CITY OF ALBUQUERQUE

**Re: Homestead Suites
Erosion and Sediment Control Plan
Engineer's Stamp Date 2-17-18 (E18E050)**

Based upon the information provided in your submittal received 2-28-18, the above referenced plan is approved to be included in the SWPPP and to apply for an ESC Permit for grading and Building Permit and to be included in the Work Order construction plans with the following note:

no.	date	remarks	by
REVISIONS			
	project title HOMESTEAD SUITES SAN ANTONIO NE ALBUQUERQUE, NM		
	sheet title SITE DETAILS		
	drawn by METO	design by JJB	project no. 1715
	sheet C1.2

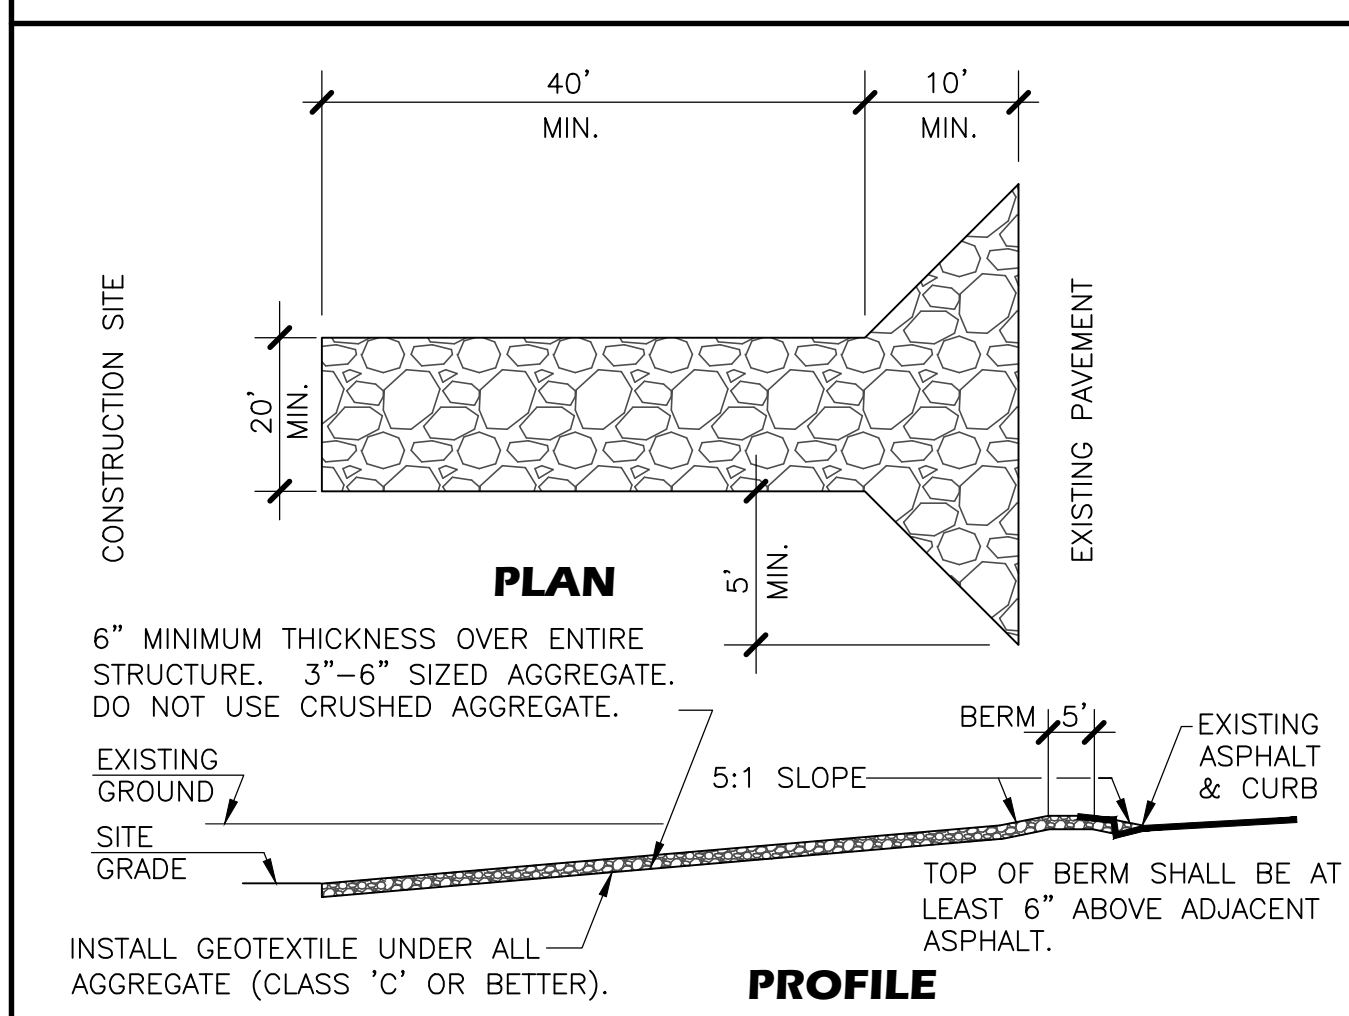
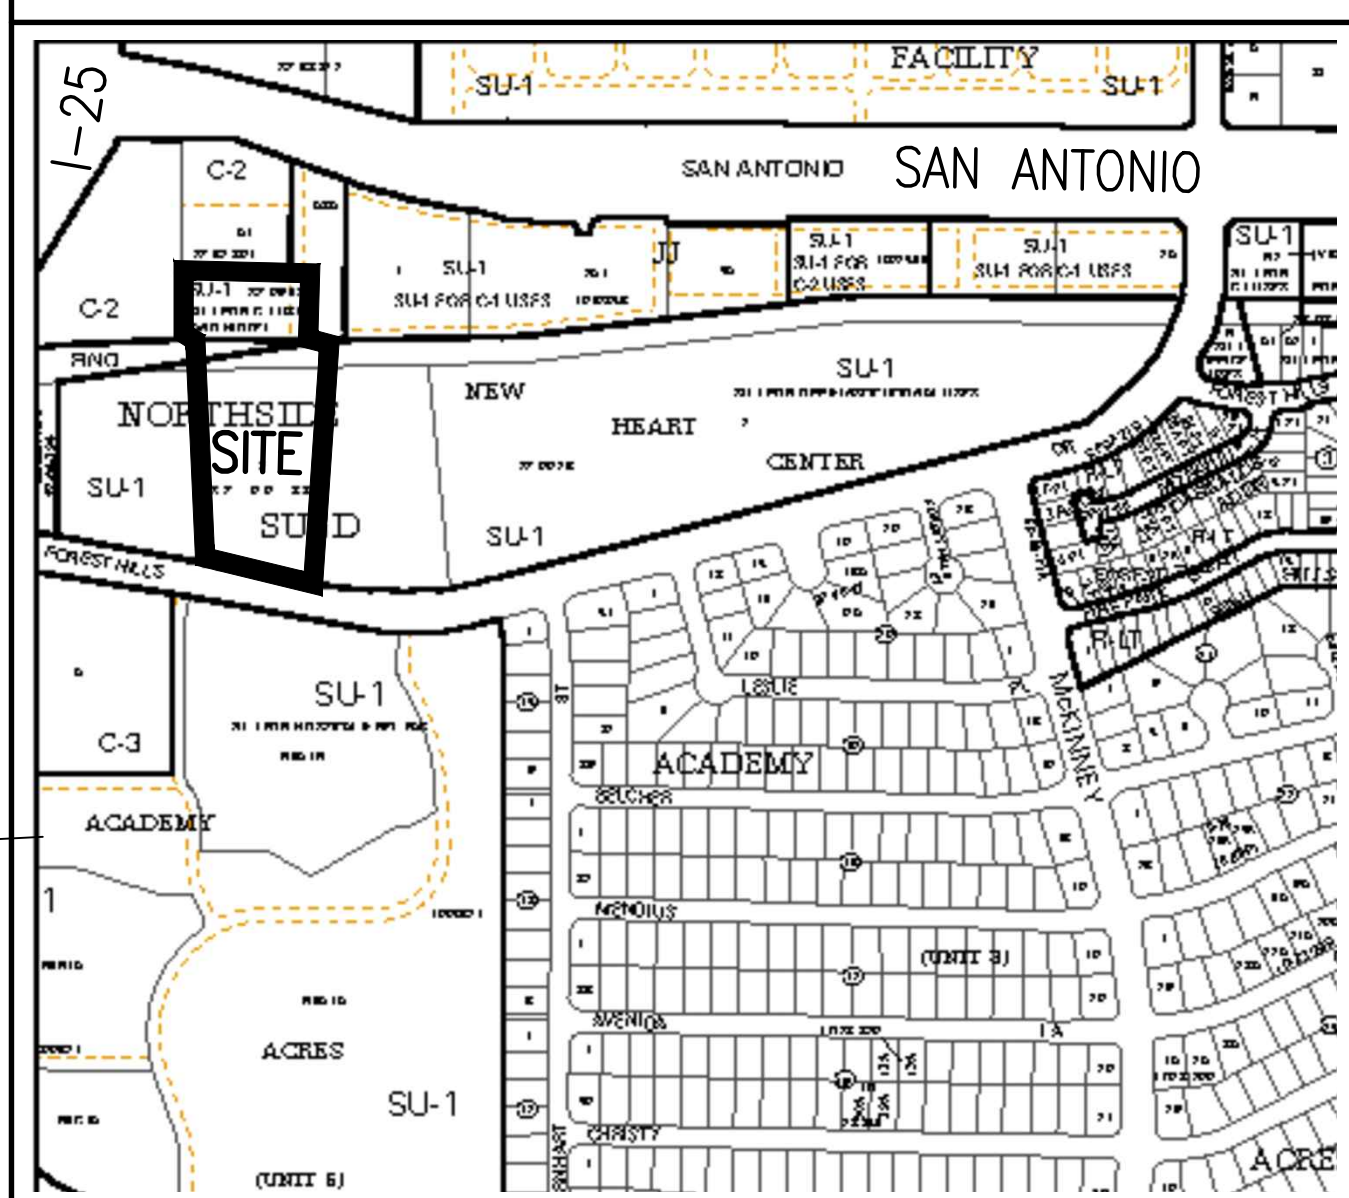
If sediment enters the channel, it is to be removed by the end of each day.
